Redfern Place – Design Review Panel No. 5 Advice

Meeting Subject:	600-660 Elizabeth Street, Redfern Design Review Panel Meeting No. 5		
Location:	In person: Ethos Urban - 180 George Street, Sydney Virtual: Teams		
Date:	18 March 2025	Time:	9:30am – 12:30pm

**Figure 4 Extract of Level 1-3 plan showing window interfacing with breezeway (lodged)**

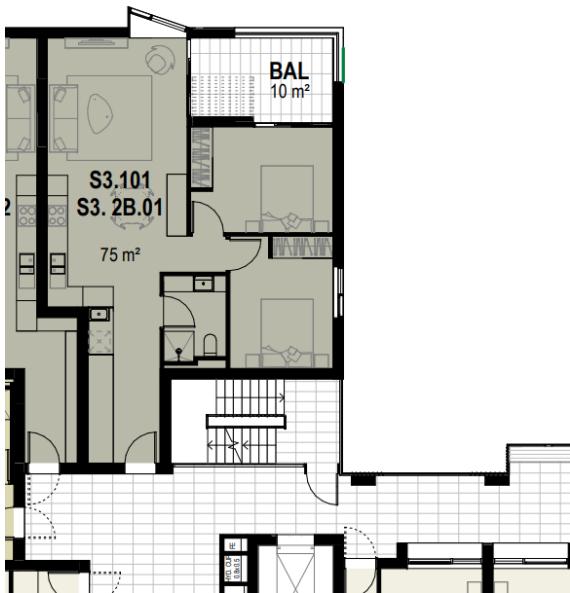
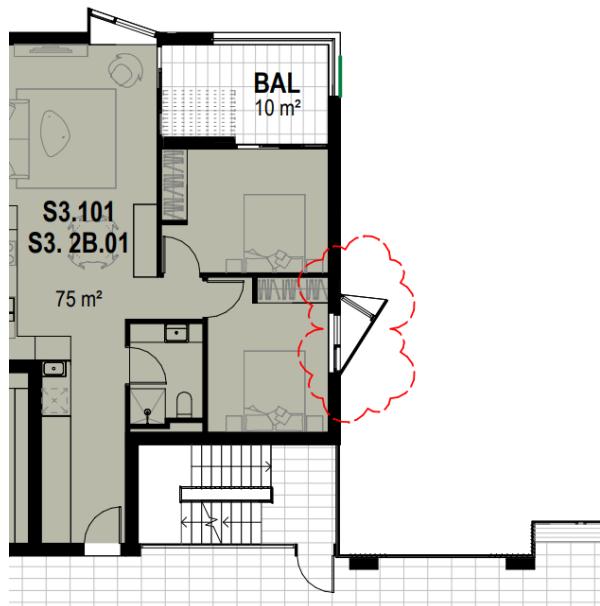
Building S3	<ul style="list-style-type: none"> • The glass line associated with the angled hooded windows is integral to the privacy solution and the glazing needs to be angled with the hood and not brought inwards to align with the external wall. • The Panel recommended the team maximise solar access to the glazing of the hooded windows rather than to the hoods themselves, to ensure quality of light in bedrooms and living spaces. • The Panel queried the inclusion and width of the column/wall (introduced since the last DRP) located vertically along the central portion of the building's eastern façade. It was preferred that the balcony outlook is maximised as much as practically possible. • Confirm requirement for retaining wall that divides deep soil zone along southern portion of Walker Street and eastern section of Phillip Street should be reviewed.

**Figure 6 Shade structures (clouded in red)**

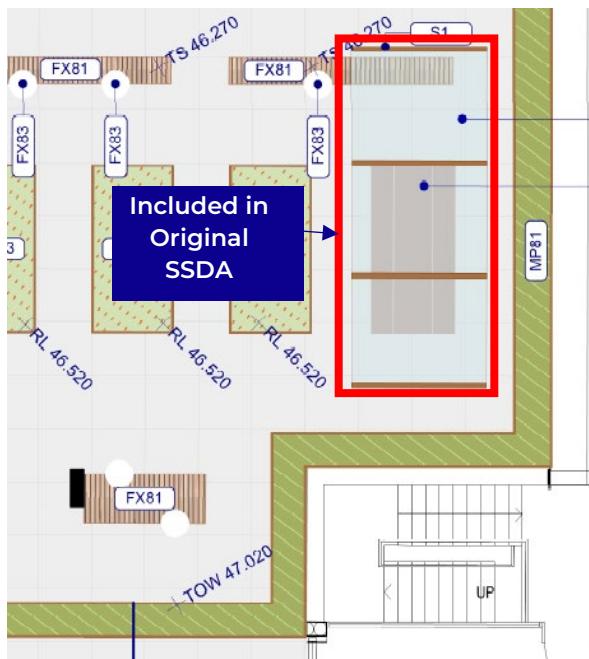
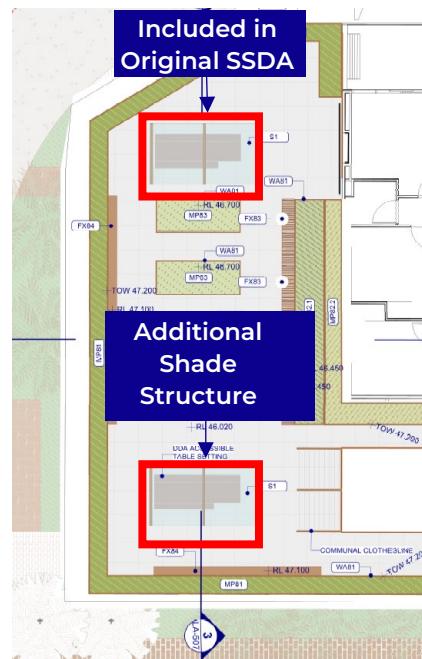
Component	Panel Commentary
Building S4	<ul style="list-style-type: none"> The Panel commended the proposal's design development, noting the careful attention and consideration given to the building's presentation to the street. The Panel noted the opportunity to further refine the rooftop being the fifth façade which will be viewed from the surrounding apartments on the site. The Panel recommended the project team explore the optimal alignment of the Elizabeth Street bus stop and the through-site link in consultation with the City of Sydney and Transport for NSW. Maximise width and soil volume in planter boxes along Elizabeth Street to ensure maintenance resilience.
Landscaping and Public Domain	<ul style="list-style-type: none"> The Panel strongly support the retention of street trees along Walker Street. The Panel recommended further exploration into opportunities to maximise and connect deep soil across the site, particularly along Walker Street adjacent to the existing street trees. The Panel was supportive of the simplification of the communal courtyard spaces. Further consideration of sightlines, particularly to building entries is recommended. Further consideration of the site's holistic connected living system approach was recommended, ensuring soil, water, biodiversity and resilience for maintenance underpin the landscaping design. The Panel recommended the drainage strategy focuses on feeding groundwater into the swales and reducing reliance on piped stormwater systems for less than 3-month events where possible. The effectiveness of swales as shown on the submitted documents was queried. The Panel encourages greater diversity of landscaping to ensure the mix and quantum of planting increases biodiversity and encourages the pollinators. The Panel recommended the team prepare a coordinated drawing which shows how the street trees, Tree Protection Zones and deep soil are integrated, as well as showing incursions caused by the proposal. The Panel noted the importance of ensuring planter boxes both at ground level and on rooftop terraces are adequately sized and designed for drainage and water access. While the Panel appreciated the difficulties with maintaining real turf on the building rooftops, it was suggested that alternative solutions to the use of synthetic turf be explored, noting it would be subject to direct extended periods of hot sun during warmer months.
